CITY OF ALBUQUERQUE

October 17, 2024

Re: Starbucks/ 2004 Wyoming Blvd. NE
1825 Edith Blvd. NE
60-Day Temporary Certificate of Occupancy
Transportation Development Final Inspection
Engineer's Stamp dated 02-26-24 (H20-D003E)
Certification dated 02-26-24

CURB RAMP IMPROVEMENTS
GRADING DETAIL

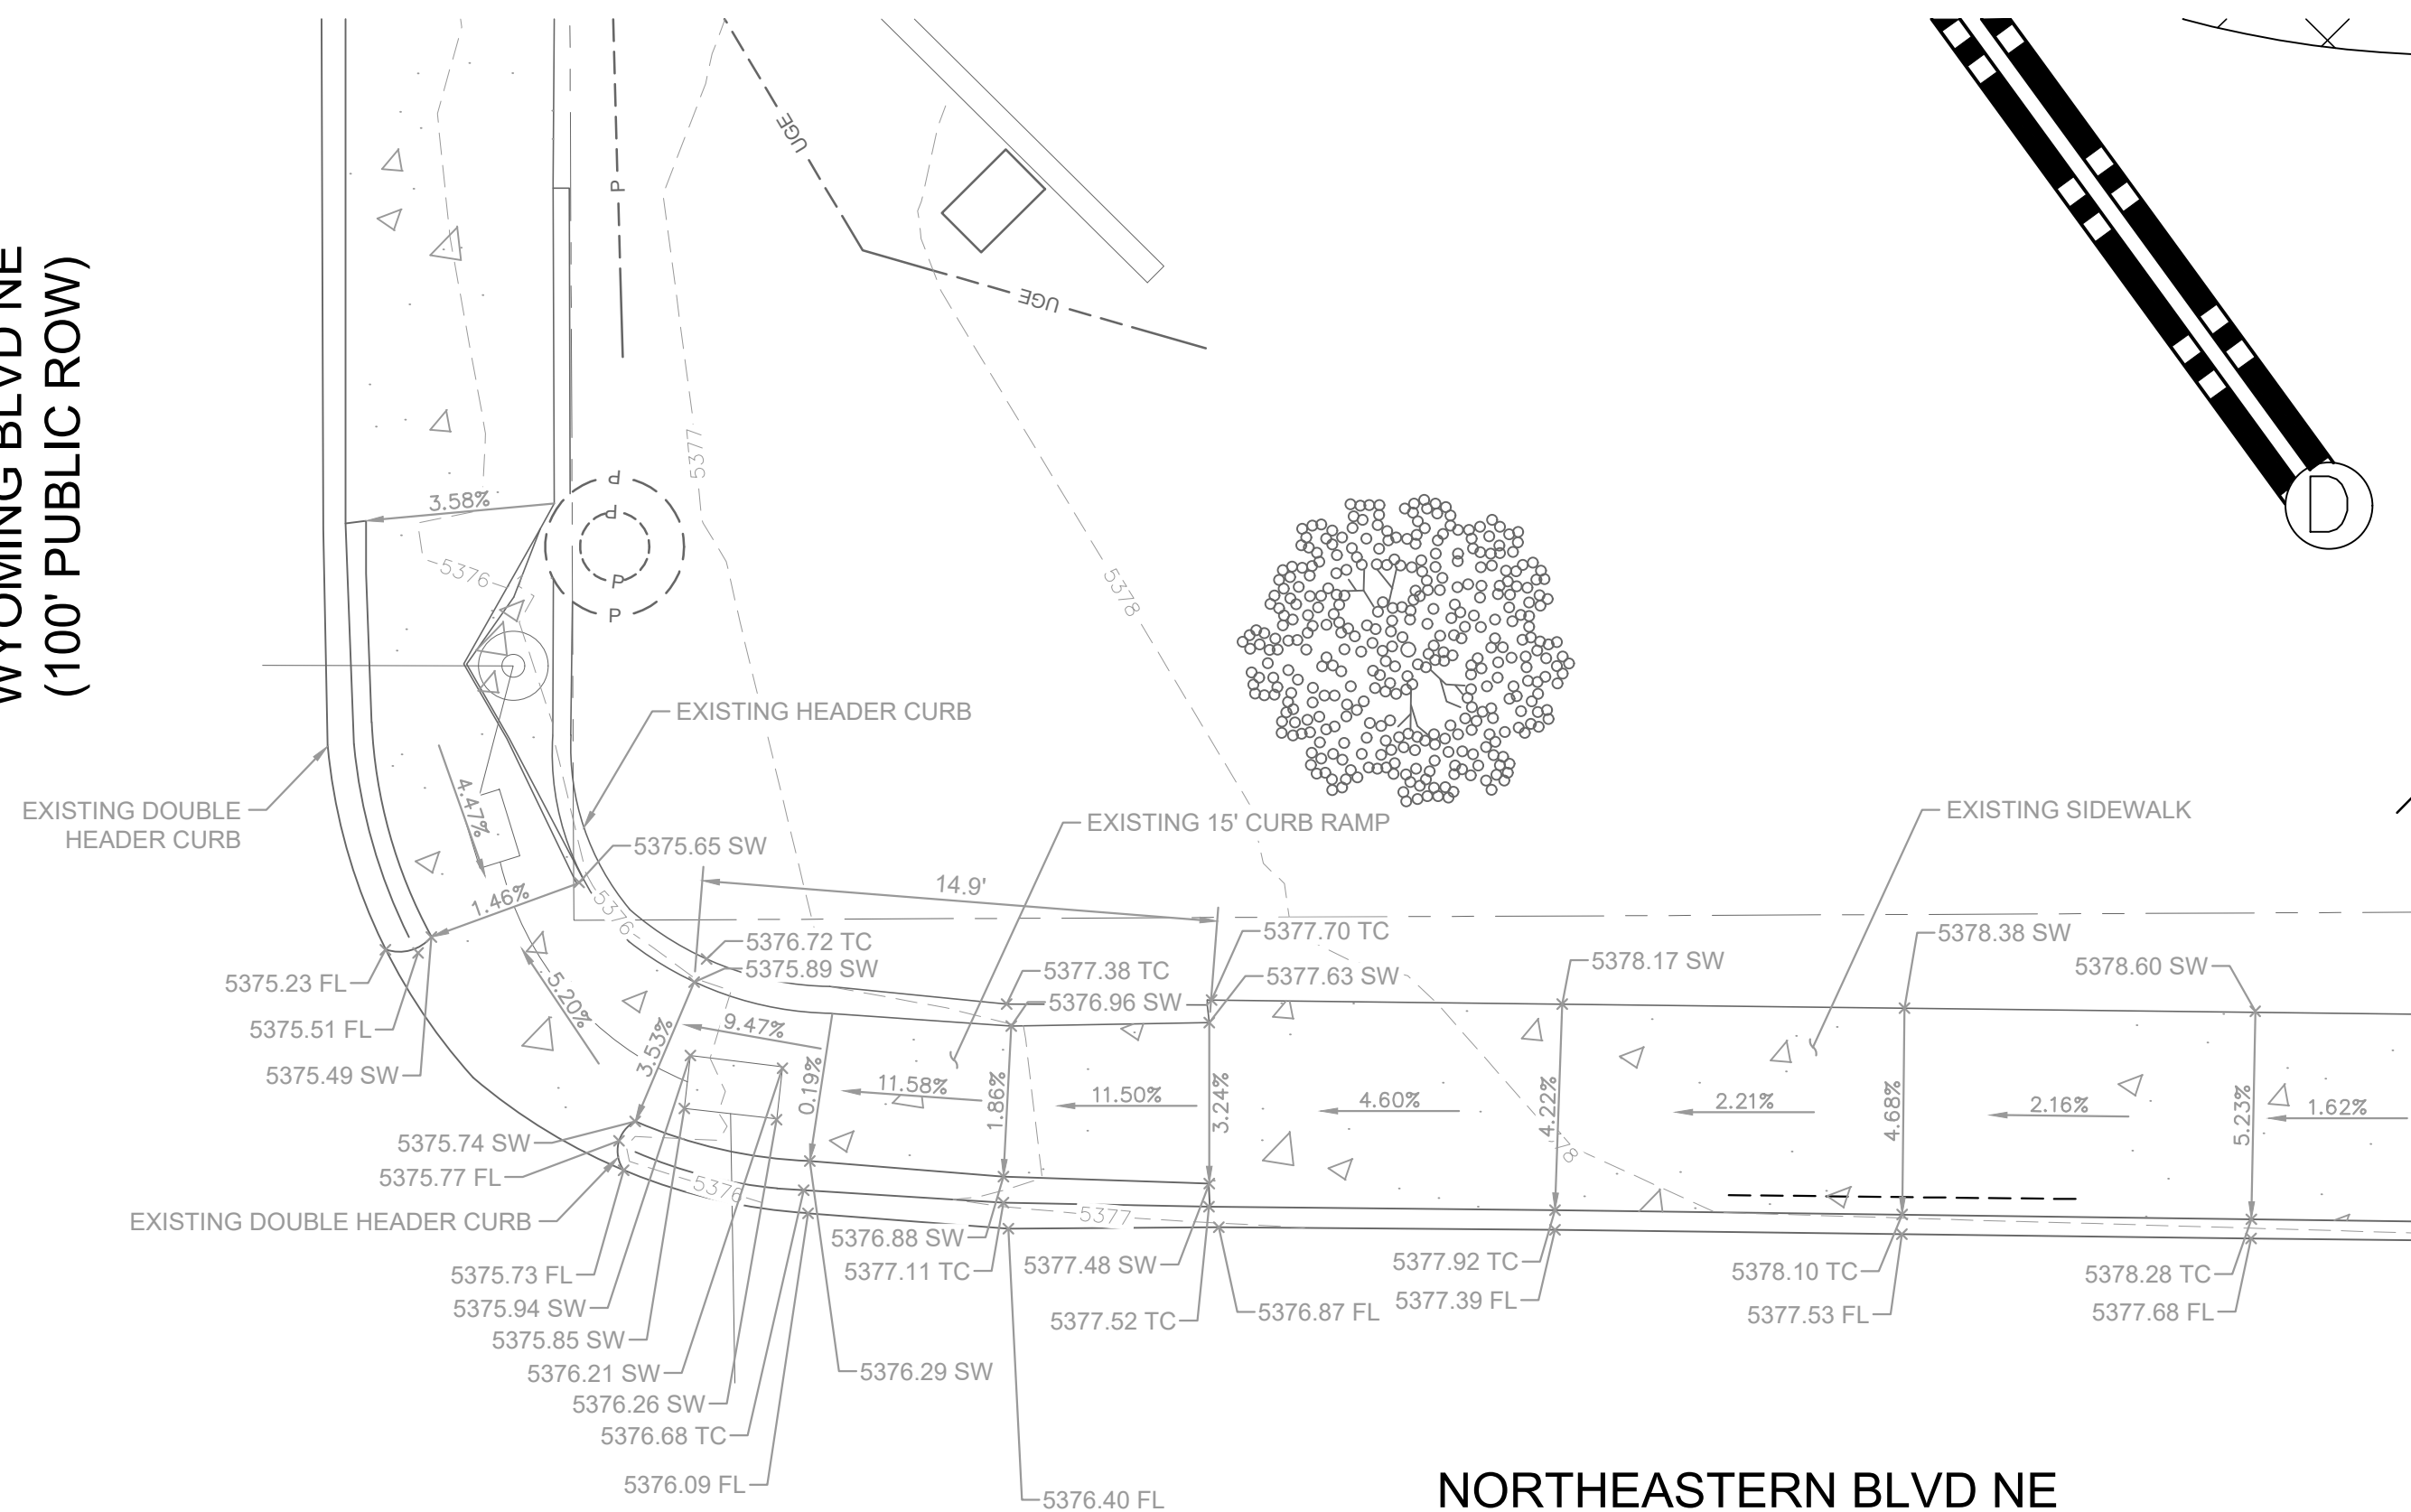
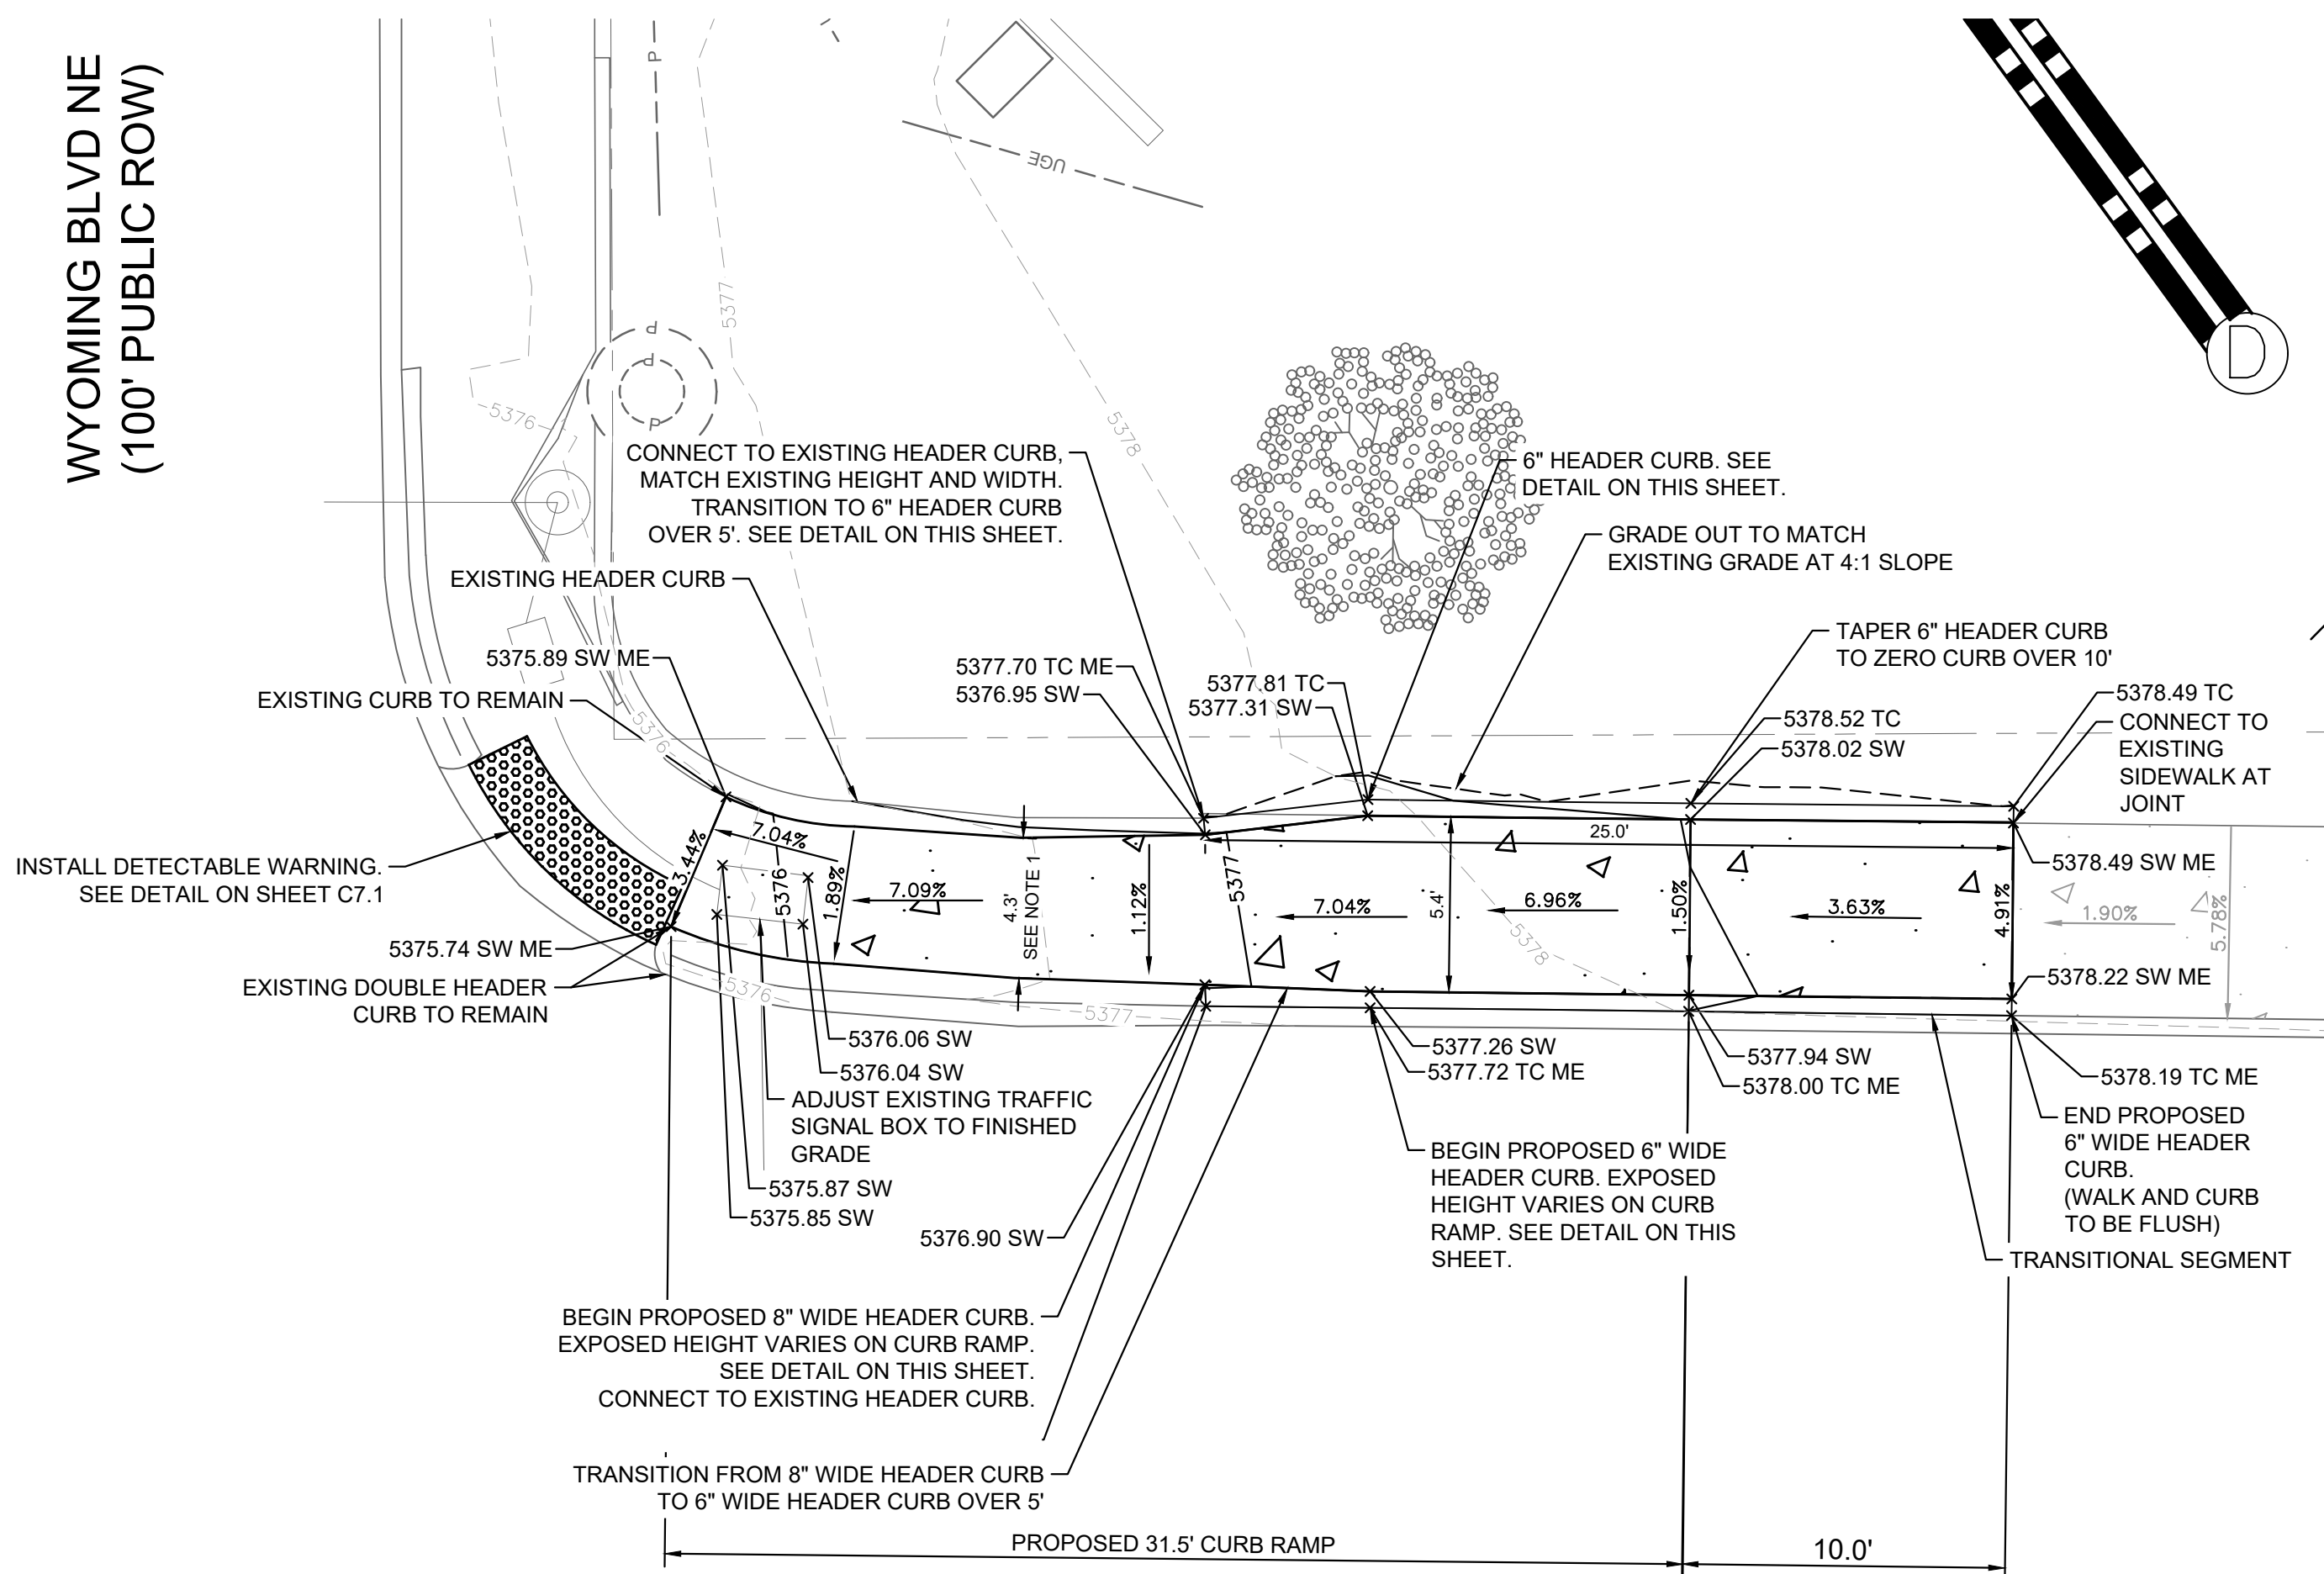
- Provide "MC" pavement marking for the Motorcycle parking spaces.
- Anchor down Bike Racks.
- The corner ramp at the corner of Wyoming blvd and Northeastern Blvd.: This ramp must be updated to the current ADA standard and has truncated domes installed. The running slope for this existing ramp is ranged between 12% and 9.9%, while the running slope for the ADA ramp should not exceed 8.3% per city standard. Also, due to the existing Traffic box, please contact the Traffic engineering department/ Traffic signal section.
